Single storey rear extension.
15 Whitfield Close Bognor Regis

Thank you for your internet representation made on 9th December 2019 which has been recorded as '**an objection**' with the comments as follows:

Plan
1 : 50

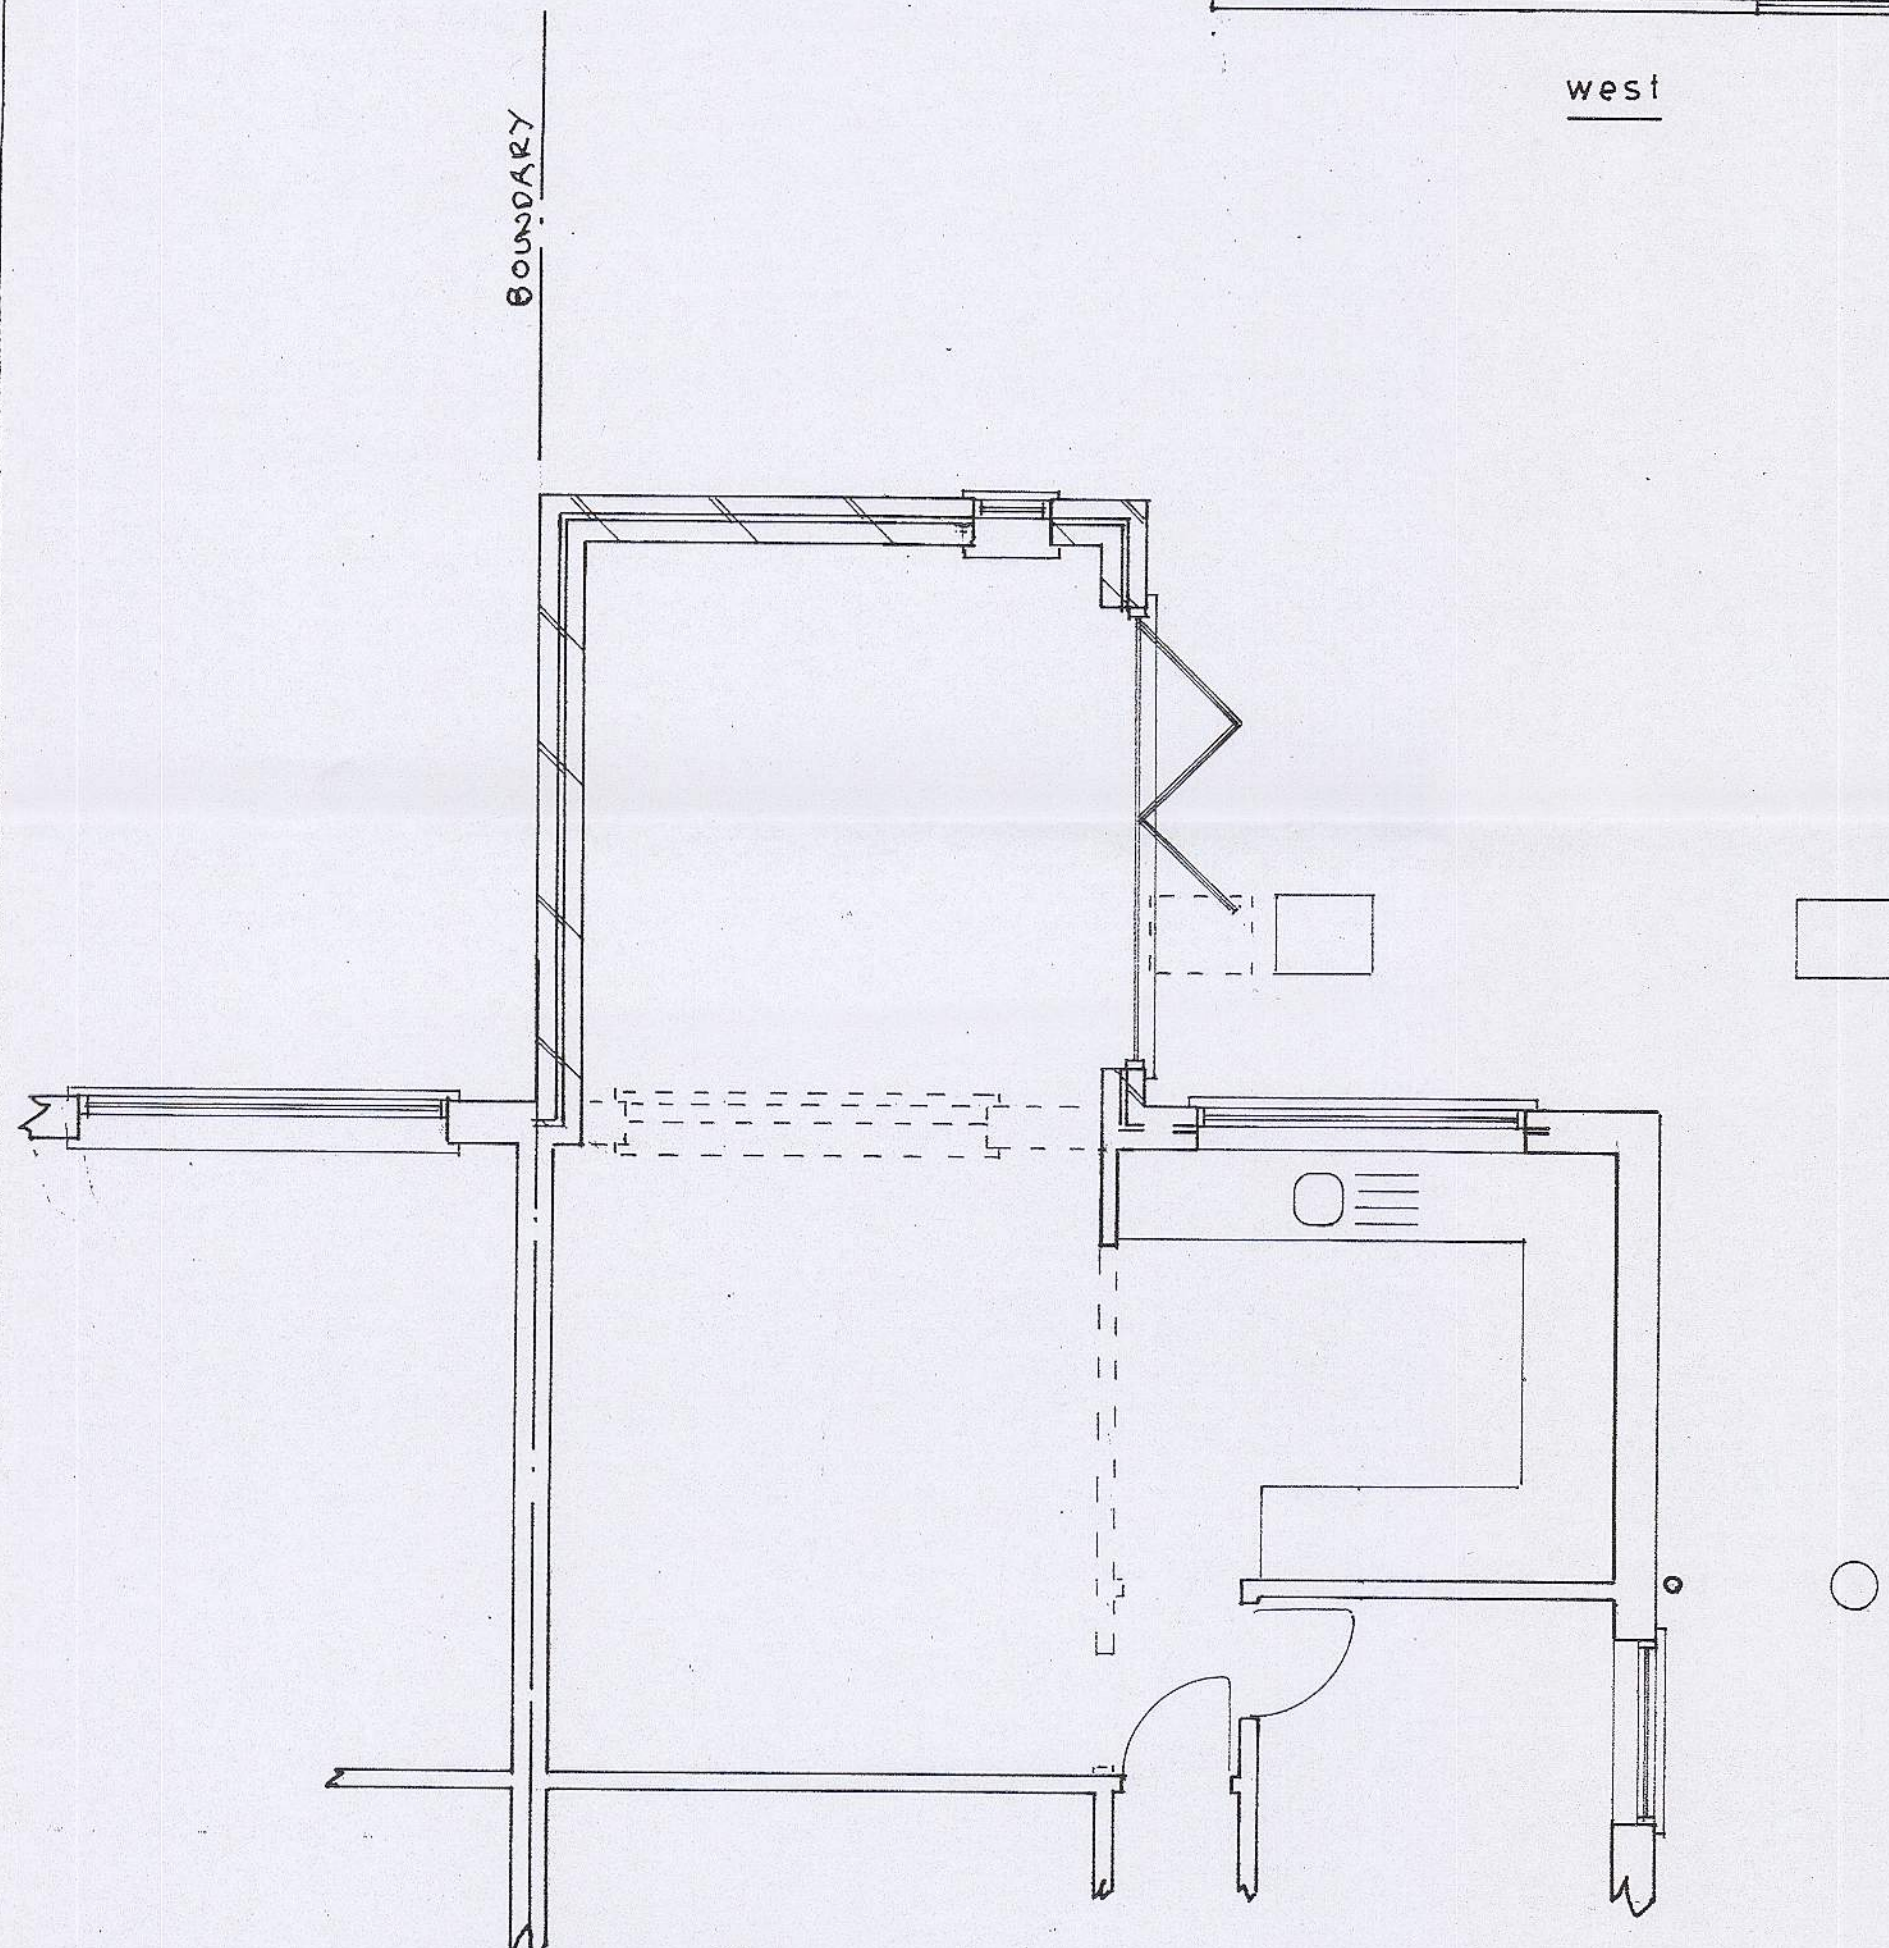
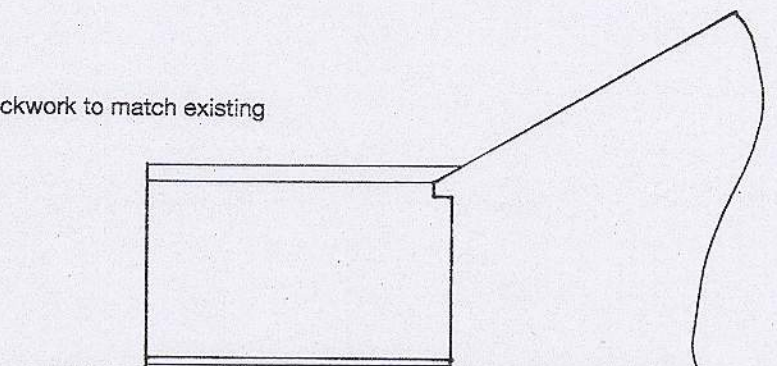
From the plans, the extension is relatively small. There are no windows my side and as it is only a single storey will not affect any light. It is quite a nice little extension. My only concern however is that the east facing wall is being built right up to the centre boundary line. Because it is so close will I be now be prevented from extending my property in the future should I wish to do so. I am also concerned that it will be practically touching my boundary fence. As I wish to maintain my privacy, and consider the security of my property, the fence panels will have to remain in position. As the fence line is within my boundary they should not need to be removed. If there is a necessity to remove the panels then they must obtain my permission before going ahead and reinstated afterwards. I also have a small cat and they have two dogs, which needs to be considered. My bedroom will also be right next to this extension as well.

I have on the whole tried to stay positive, and feel I have given fair comments. I know that there will be a considerable amount of disruption, as with any project of this nature. I would be grateful if the building control officer would answer my concerns, especially regarding the east facing wall. I will have to maintain my objection at the moment because of my concerns over the east facing wall.
